Subject: TCL (E17D041D) Comment Responses

arcLINE Architectural Design LLC has reviewed and responded to comments generated on 03-26-2024. Please see comment and response below.

A1 SITE PLAN  
1" = 20'-0"

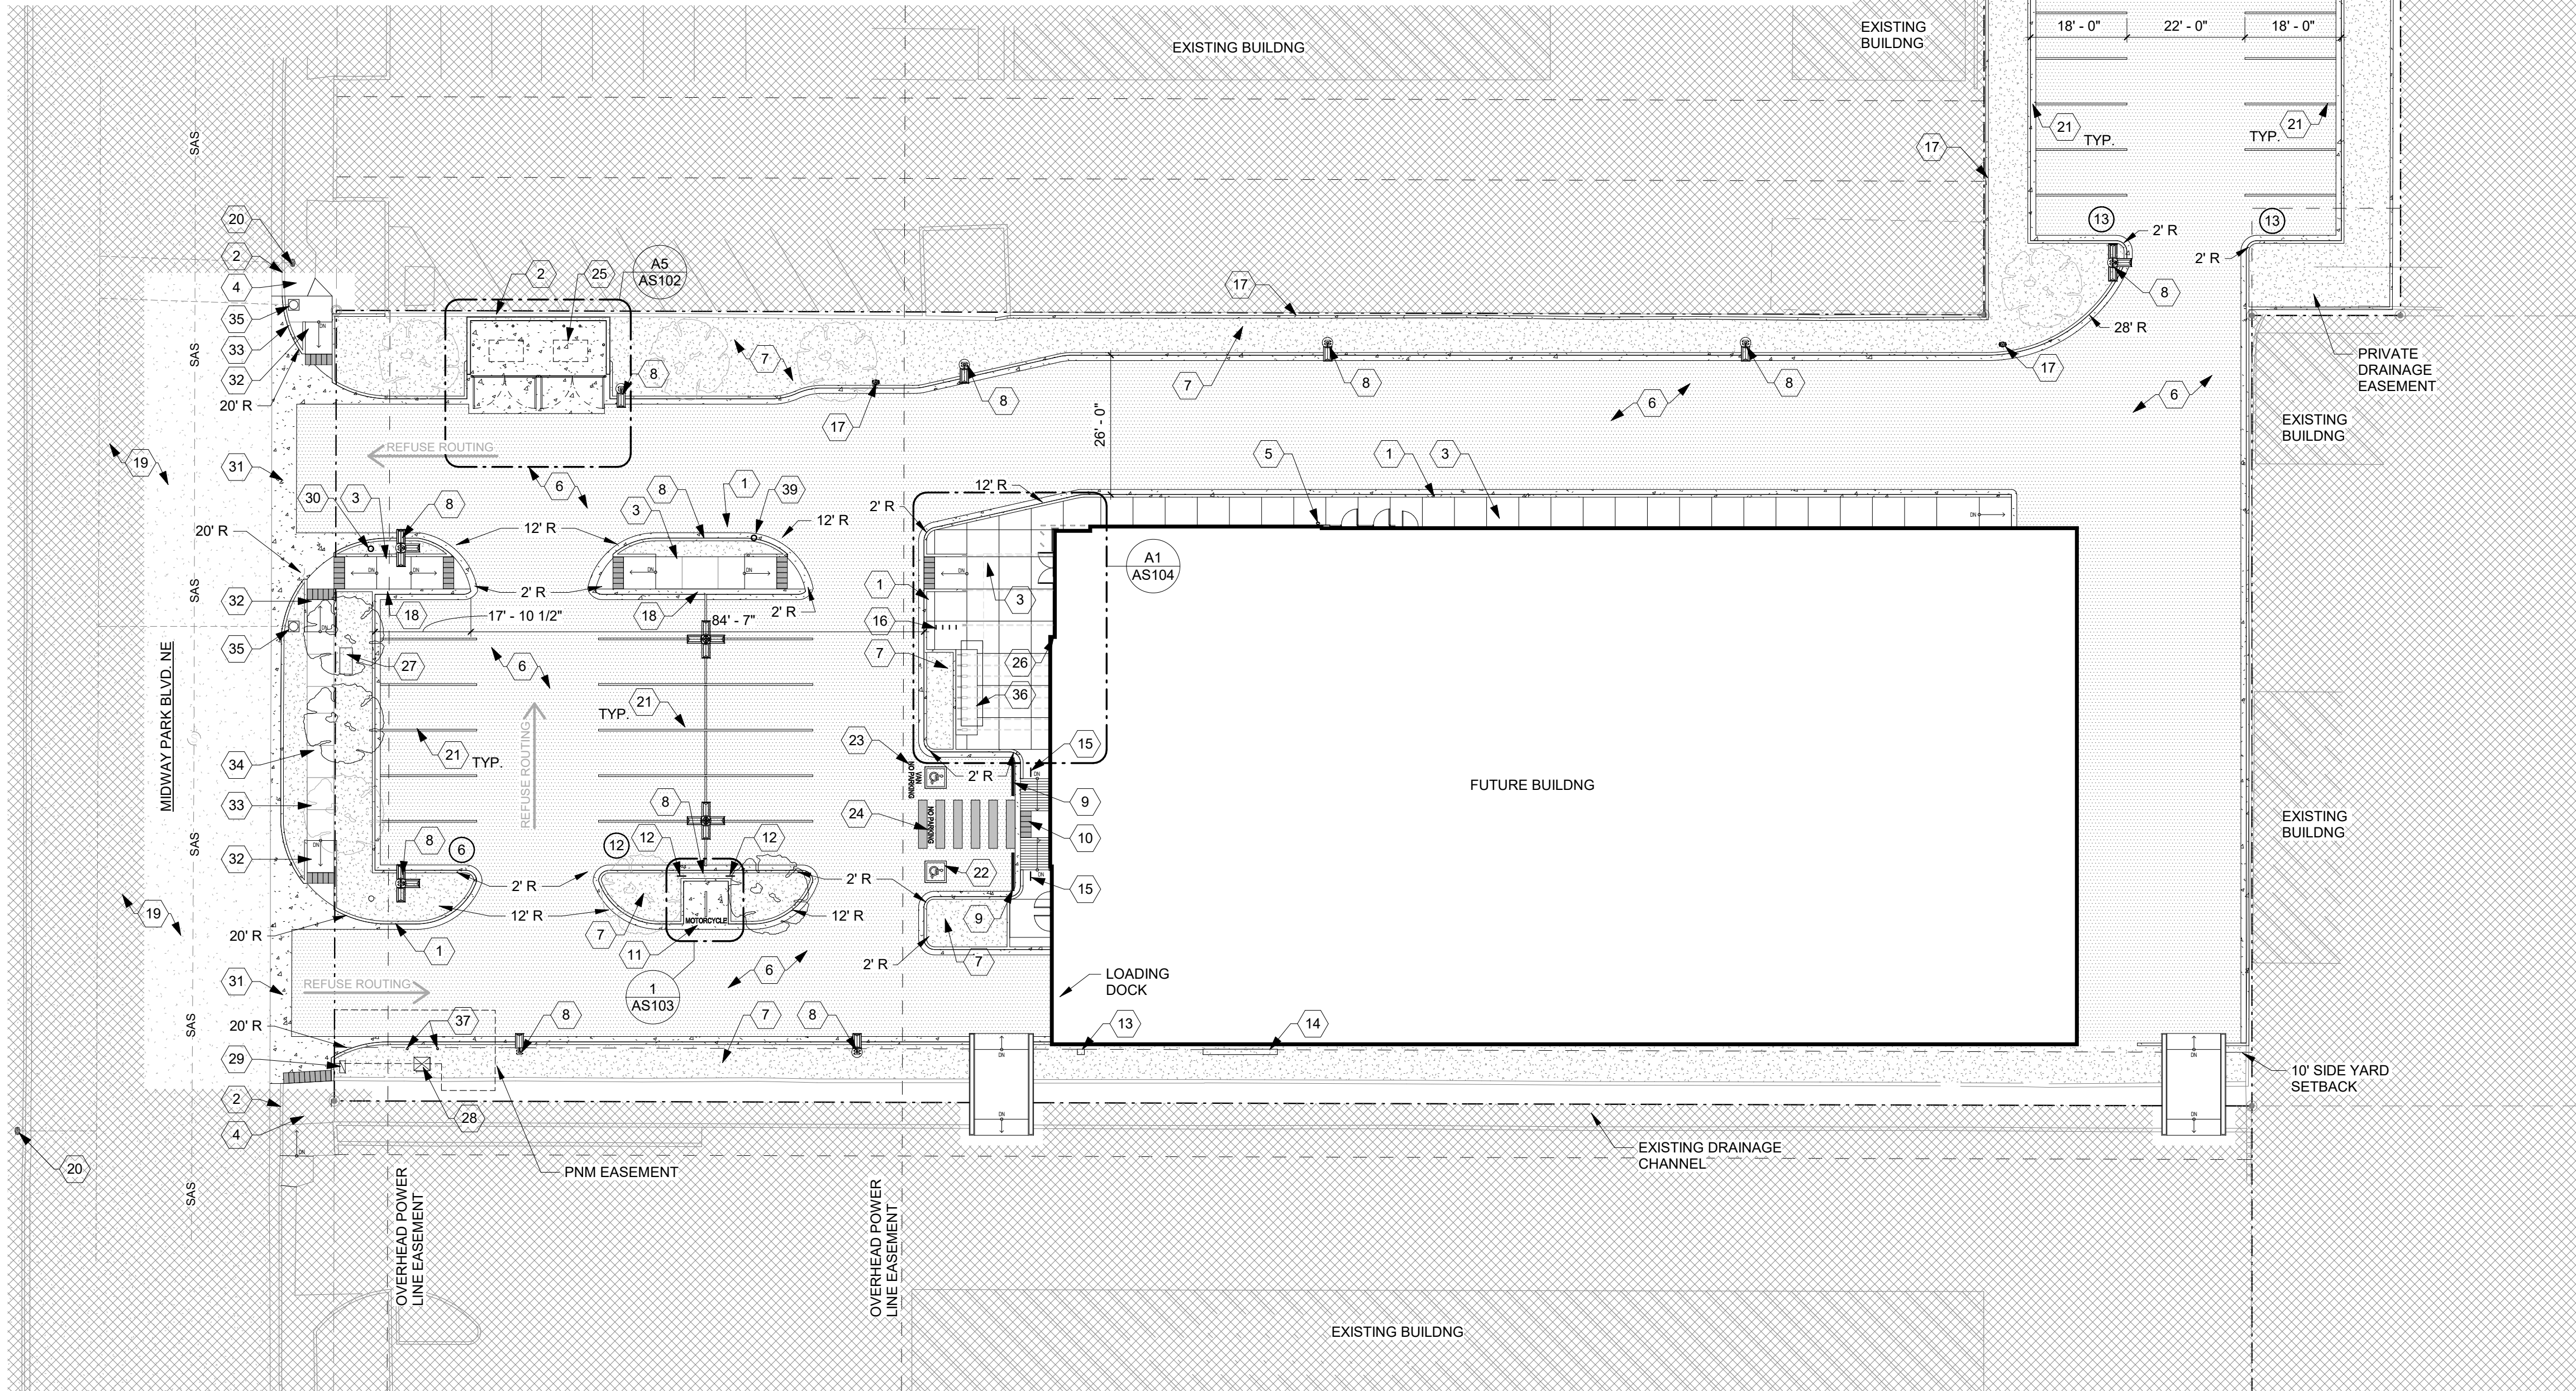
- 1. It appears the keyway in the North parking lot may be 5' deep due to the 4' radius, but please clarify with a depth dimension.
 - a. A dimension has been added to the site plan sheet AS101.

- 2. Provide drive aisle widths west and north of the building. The north-south aisle closest to the building does not appear to be the minimum of 22' wide for 2-way traffic.

- 3. The loading dock in the front of the building may create conflicts with the retail/office circulation in the parking lot. Provide the size of the vehicle that will be using the Loading Dock and show delivery vehicle travel pattern. This will help determine whether the loading dock will need to be moved to the back of the building/ separated from the retail/office circulation.

- 4. The southern curb return of the southern drive entrance does not tie properly/provide continuous radius to the curb ion Midway Park Blvd. It should look like the northern curb return. This entrance will have to be shifted north.

- 5. Provide sidewalk widths. The sidewalk along Midway Park Blvd is to be a minimum of 5' wide.
 - a. Dimensions have been added to the site plan sheet AS101.

- 6. Provide parking stall widths.
 - a. Dimensions have been added to the site plan sheet AS101.
- 7. Provide accessible aisle width and depth.
 - a. Dimensions have been added to the site plan sheet AS101.

- 8. A 6 ft. wide ADA accessible pedestrian pathway is required from the Public sidewalk to the building entrance(s). Please clearly show this pathway and provide details.

- a. Dimensions have been added to the site plan sheet AS101.
- 9. For the van accessible parking space, add the "Van Accessible" sign (see attached image). I think the "Van No Parking" pavement markings is misleading and it is non-standard, so these pavement markings can be removed. I attached an image for the DPM.

- 12. Provide the widths of the proposed drive entrances.
 - a. Dimensions have been added to the site plan sheet AS101.
- 13. Provide the size of the vehicle to determine curb return radii of the drive entrances.

- a. The Fire Marshal and Solid Waste Department approvals are attached.
- Add a Note that broken or cracked sidewalk in the City ROW shall be replaced per COA STD DWG 2430.

- a. Detail C2/AS102 has been revised to indicate the proper spacing.
- 17. Show the clear sight triangle and add the following note to the plan: "Landscaping and signage will not interfere with clear sight requirements. Therefore, signs, walls, trees, and shrubbery between 3 and 8 feet tall (as measured from the gutter pan) will not be acceptable in the clear sight triangle.

- a. Dimensions have been added to all drive aisle widths, including the aisles closest to the building which is now indicated at 22'. See attached sheet AS101.

- a. A straight box truck with 26-foot bed or shorter will make deliveries to this location. Any deliveries on a semi-truck is delivered to a different location and brought to this location via a box truck. A 35' box is indicated at the loading dock to show minimal interference with the adjacent circulation.

- a. The drive has been shifted north to allow the proper radius and accessible sidewalk ramp. A steel channel cover has been added to the project to allow the flow of water without pedestrians walking through it. The adjacent sidewalk will be replaced to meet up evenly.

- a. The wording has been removed from the plan sheet AS101.

- a. A note has been added along Midway Park Blvd.
- 16. Detail C2, Bicycle Rack, revise the spacing between the racks as a bicycle parking space is 6' long x 2' wide.

- a. The clear sight triangle and note has been added to the site plan sheet AS101.
- 18. Provide Sheet AS103.
 - a. There is no sheet AS103, the reference was included by mistake. The motorcycle enlarged plan has been added to sheet AS102 detail D5.

**B2** ACCESSIBLE/MOTORCYCLE PARK. SIGN  
1 1/2" = 1'-0"

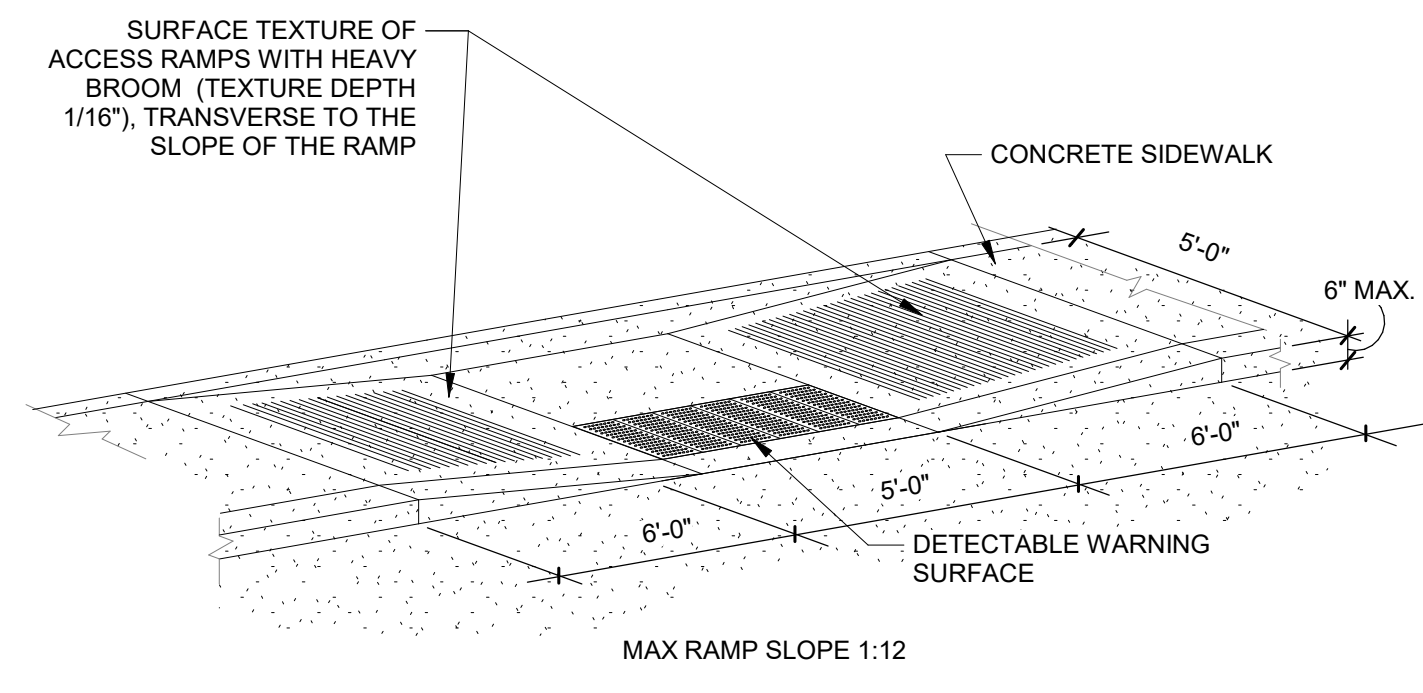
- 10. The bottom of the motorcycle parking sign is to be a minimum of 4' off the ground and the accessible sign 5' off the ground. Revise Detail B2.

- a. Detail B2/AS102 has been revised.
- 11. Please discuss what appear to be two bridges across the drainage channel. They do not appear to be for vehicles, but please state the purpose/usage. Since the southern portion is on the adjoining lot, written approval (email or letter) from that property owner is required.
